Online Comment

Application H16-0687-25
Location Sir Halley Stewart Playing Field Winfrey Avenue Spalding PE11 1DA
Proposal Construction and operation of a micro energy storage project

Name Diane Gordon
Address SHDC Environmental Protection

Date Submitted 13-08-25
For/Against Comments

Figure 3-3: Night-Time BS4142 Assessment

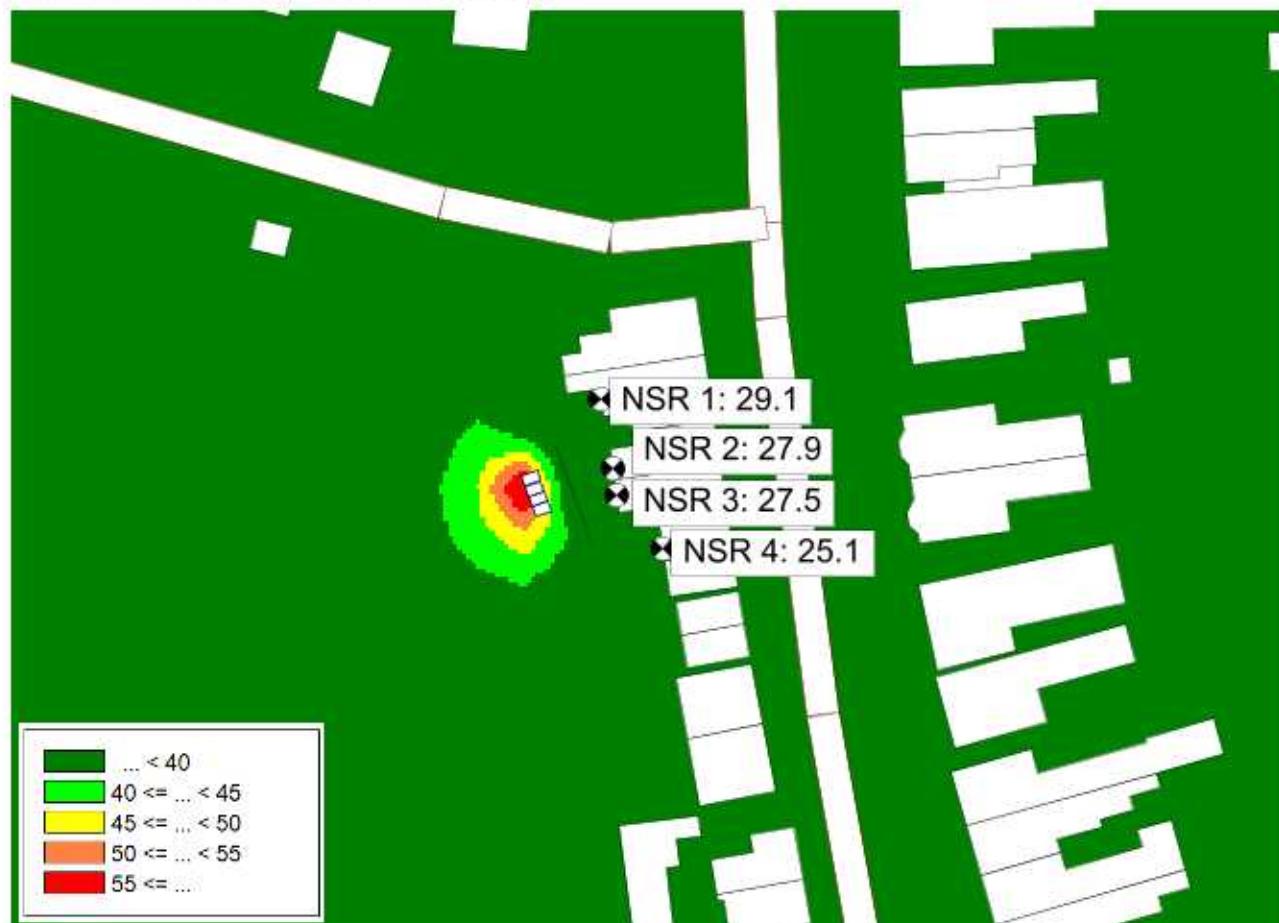
provide additional data to enable a noise assesment to be made regarding potential impact to 39-43 Pinchbeck road. although noise assesment for the BESS system is provided distance from source and background night time noise levels are not available to make proper assesment of potential impact.
